**Oakdale West Estate Modification 6 (SSD-7348-Mod-6)
Request for Additional Information**

Attachment 1 Department's Comments on the Environmental Assessment

GENERAL ARRANGEMENT
PLAN

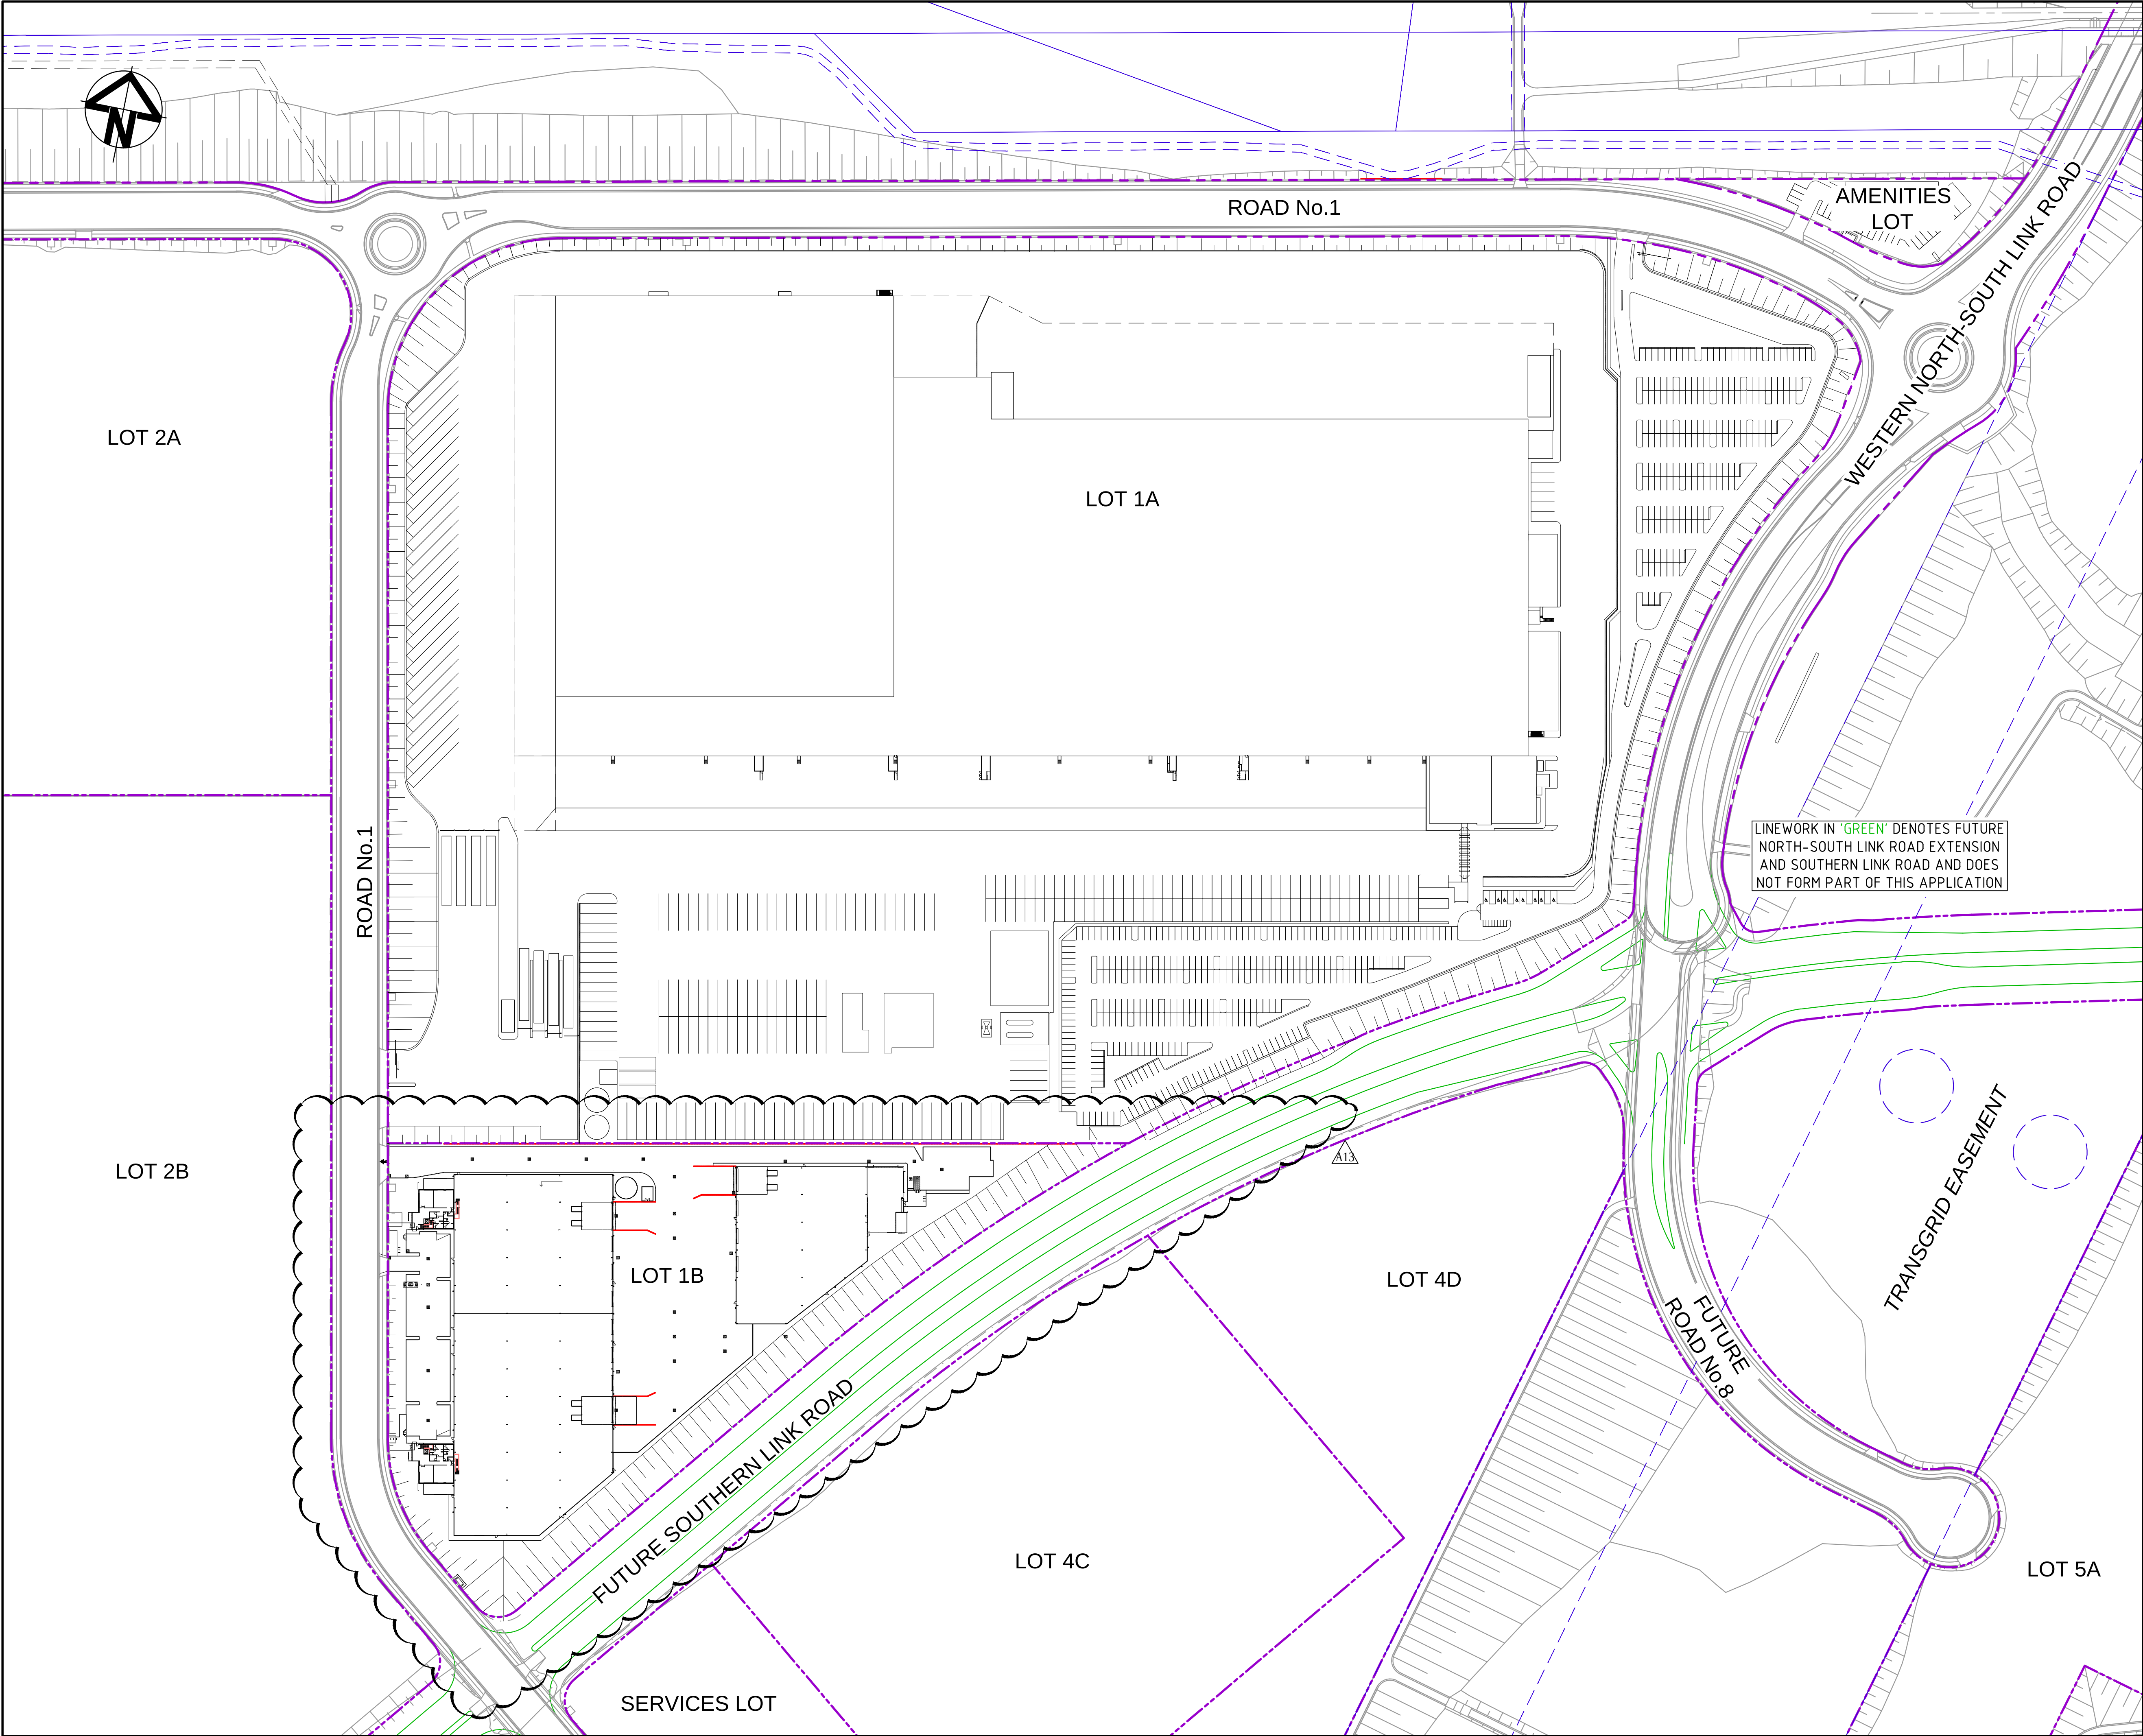
3. The Department notes the layout for Precinct 1A shown in Civil Drawings for Buildings 1B and 1C is inconsistent with the Precinct 1A layout approved under SSD-7348 MOD 5. Please update the Civil Drawings for Buildings 1B and 1C to ensure the Precinct 1A layout is consistent with what has been approved under SSD-7348 MOD 5.
